Our Ref: TR040011

Planning Act 2008 – Section 51

Application by North Somerset District Council for an Order Granting Development Consent for the Portishead Branch Line – MetroWest Phase 1

Advice following issue of decision to accept the application for Examination

Figure N-23: Pre Development, 20year return period event in 2115 ,Tidal

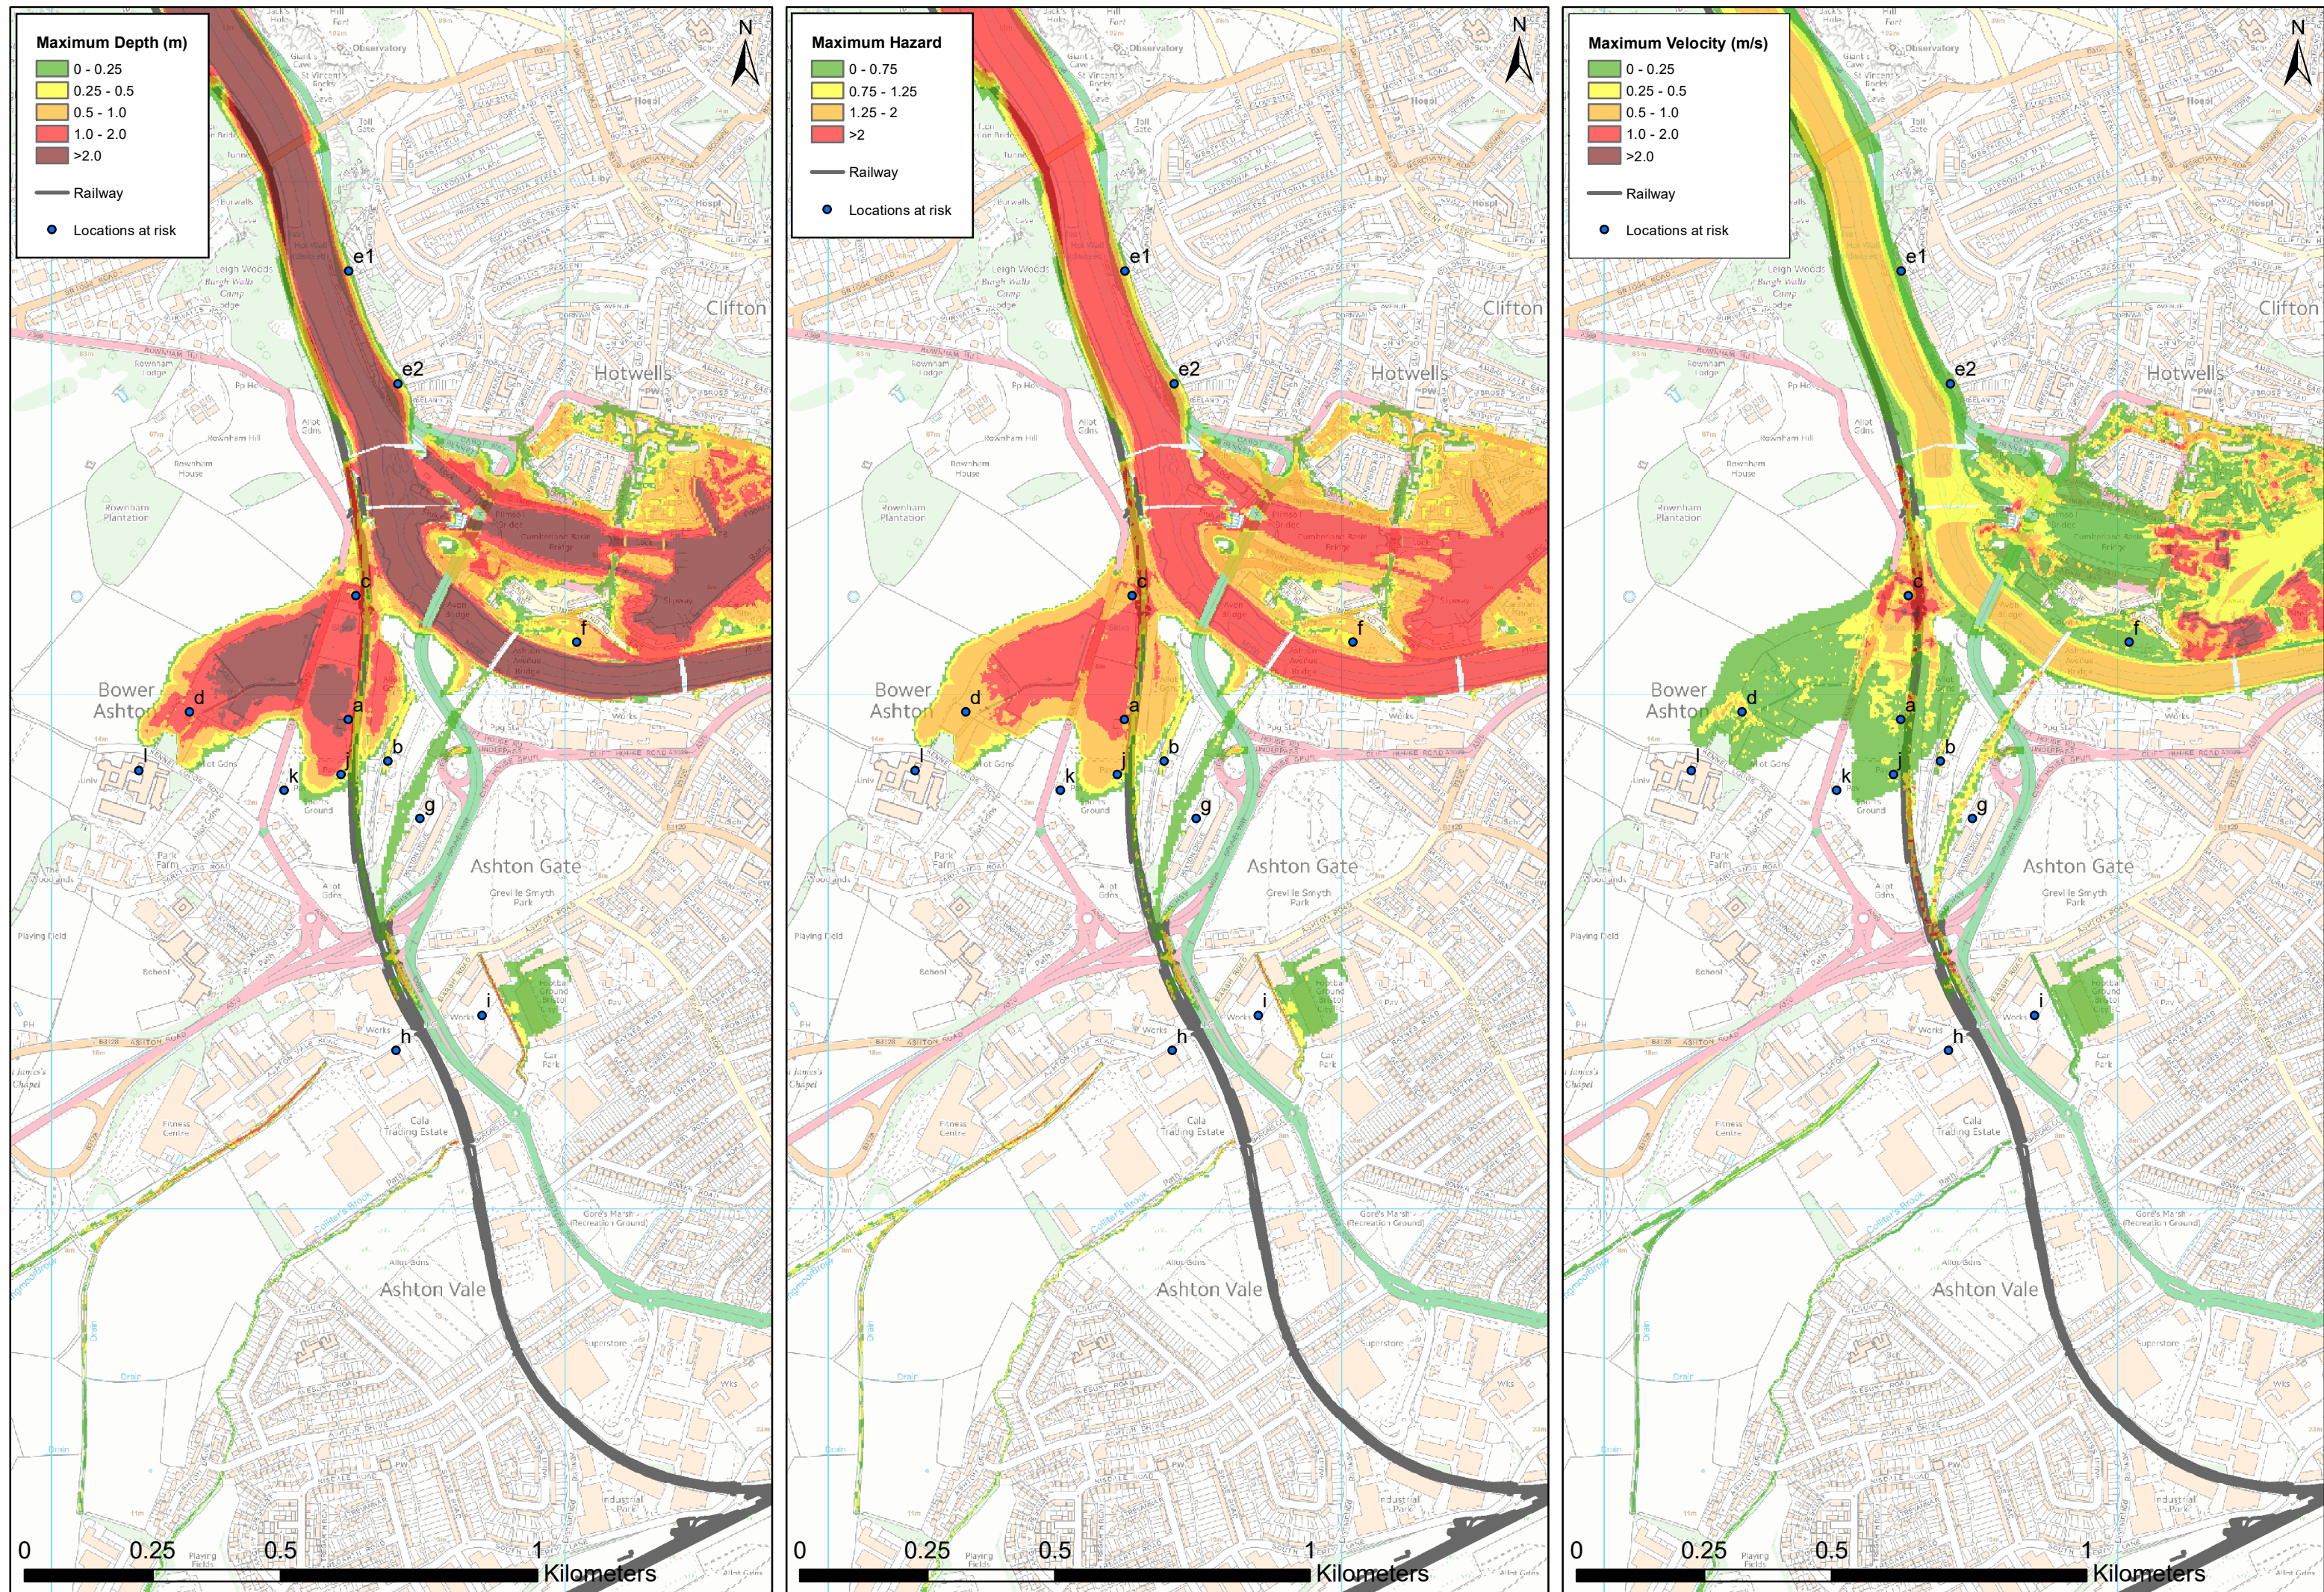
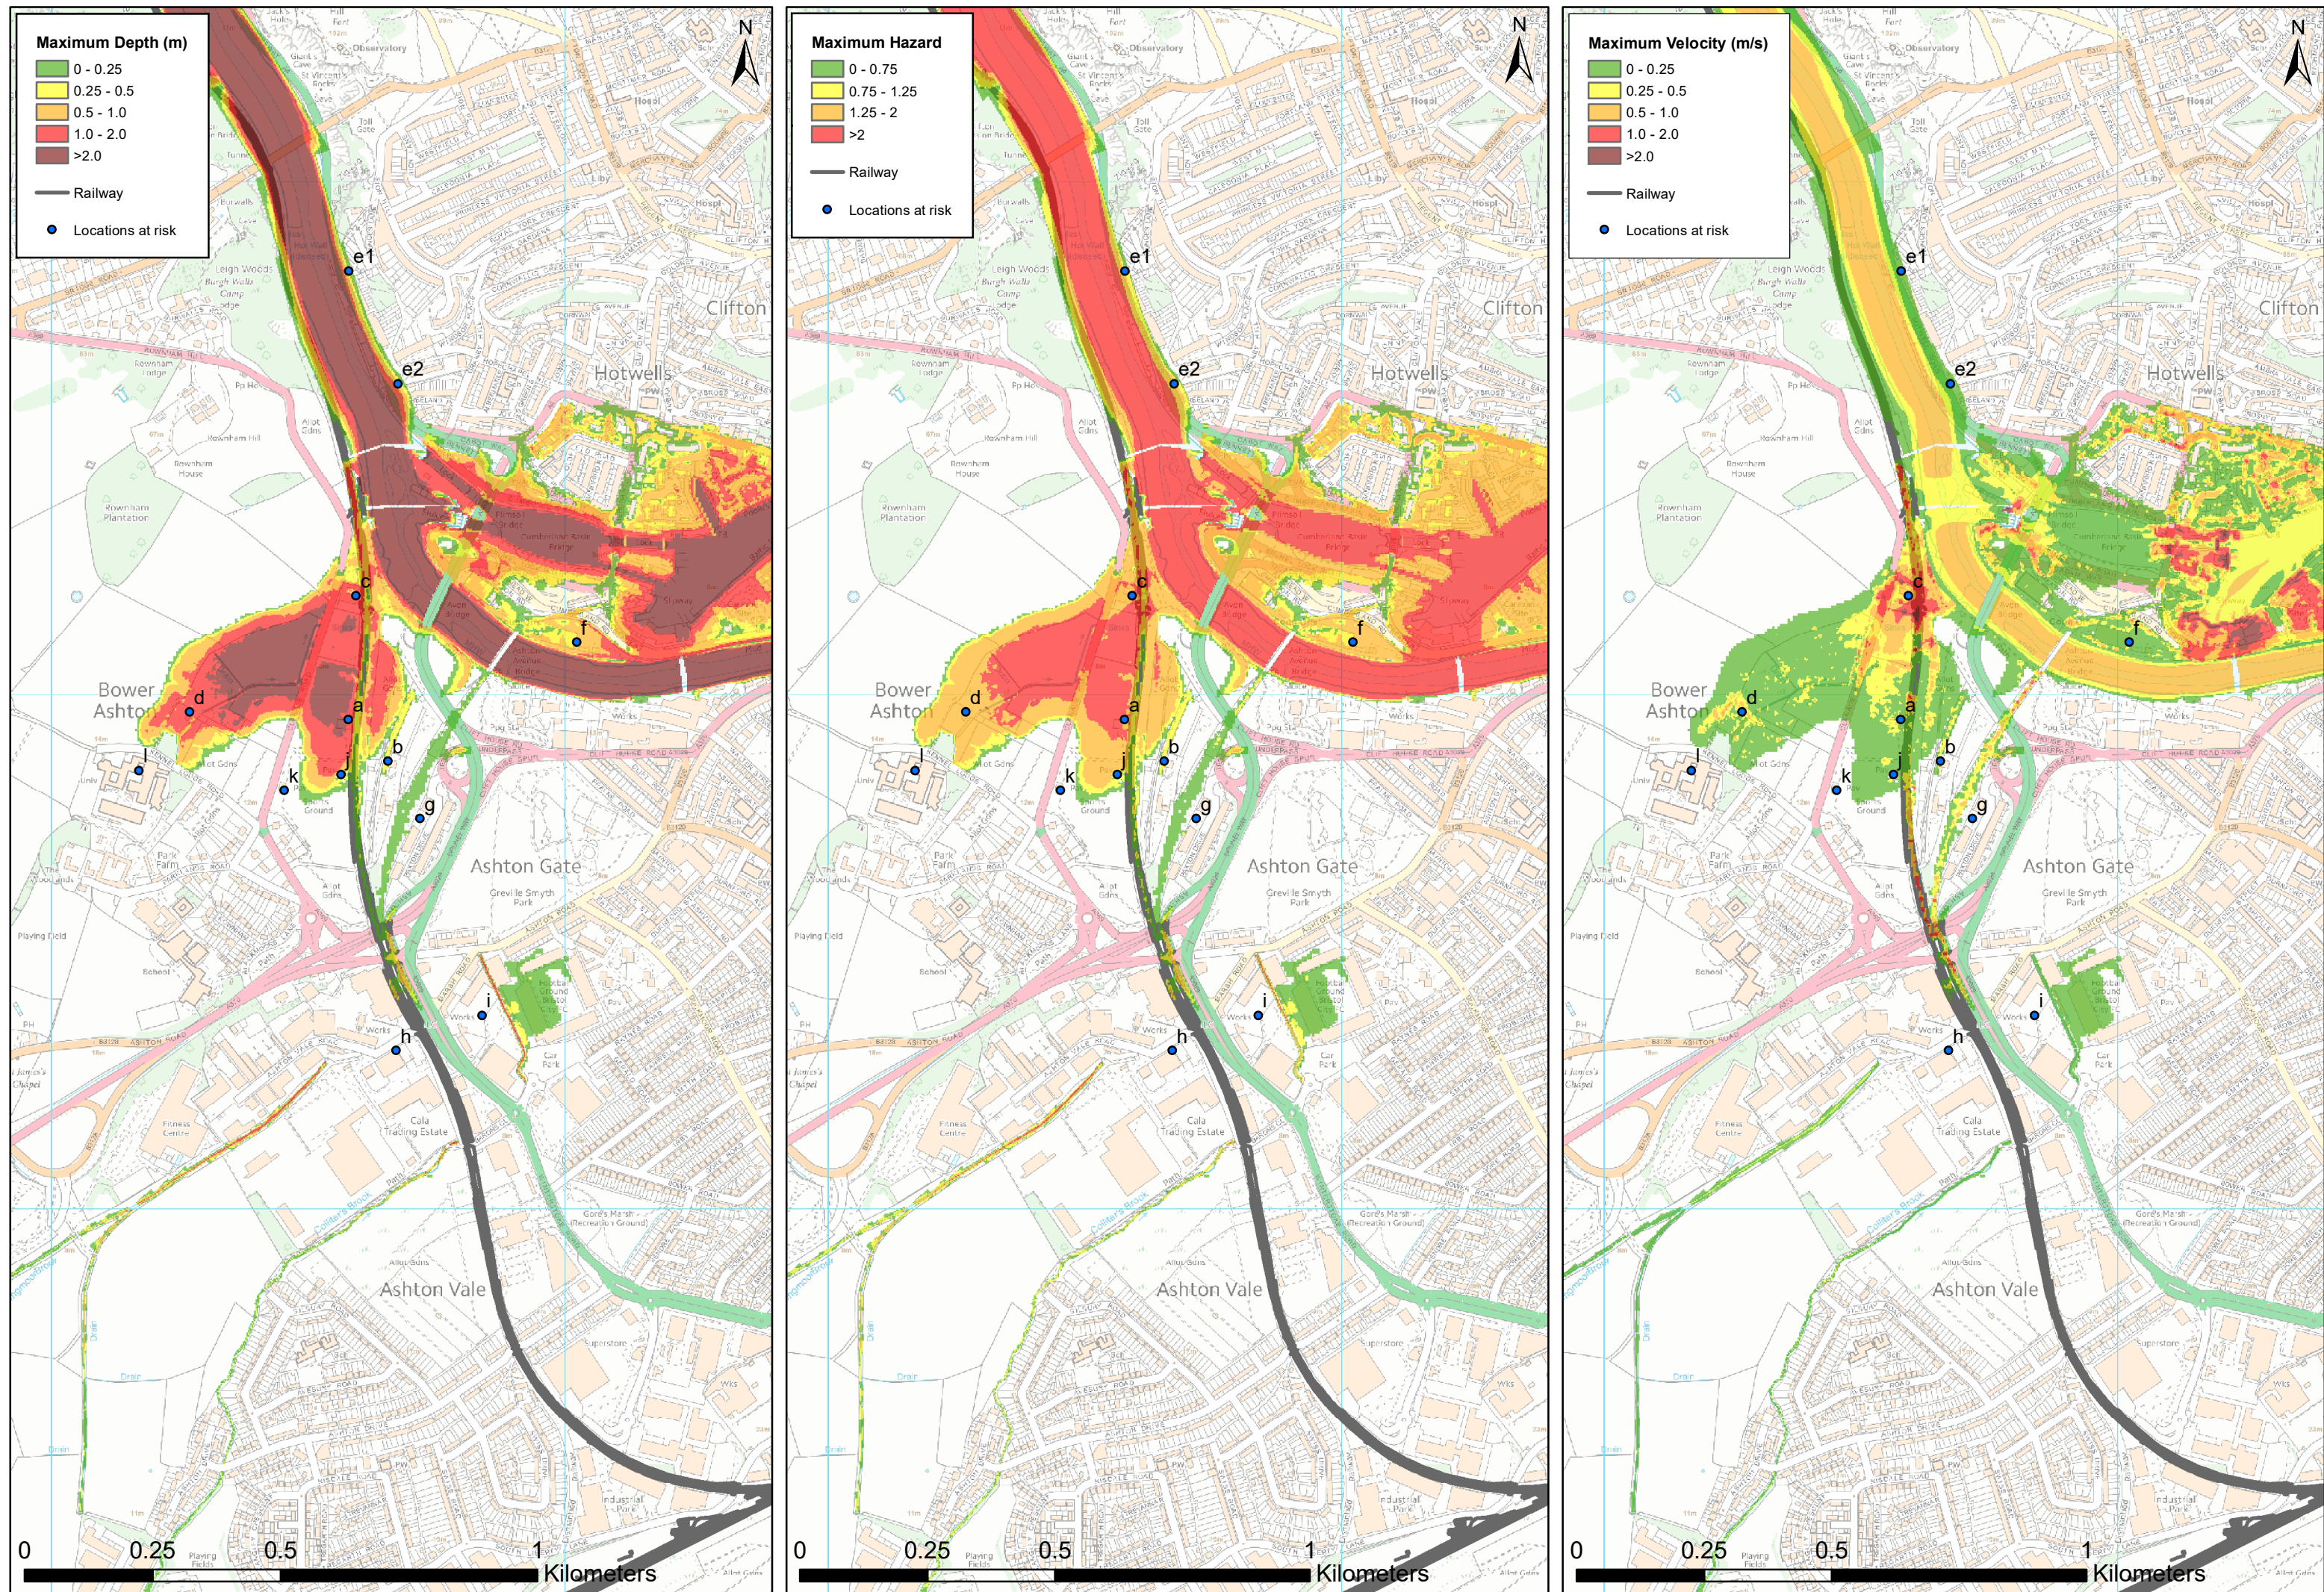
At Bower Ashton - the simulation of impacts from River Avon tidal flooding indicates that this section of the operational NSIP would experience tidal flood events once every 5 to 10 years for the assessment year (taken to be 2015) and more than once a year on average in the future (scenarios 2075 and 2115) (taking into account climate change, including sea level rise, into consideration). In preparation for the examination the Inspectorate seeks to understand the extent to which the application of the revised climate change allowances may (or may not) affect the findings in this regard. In particular, whether such detail would result in anticipated flood events at more frequent intervals and at earlier points in the design life of the Proposed Development.
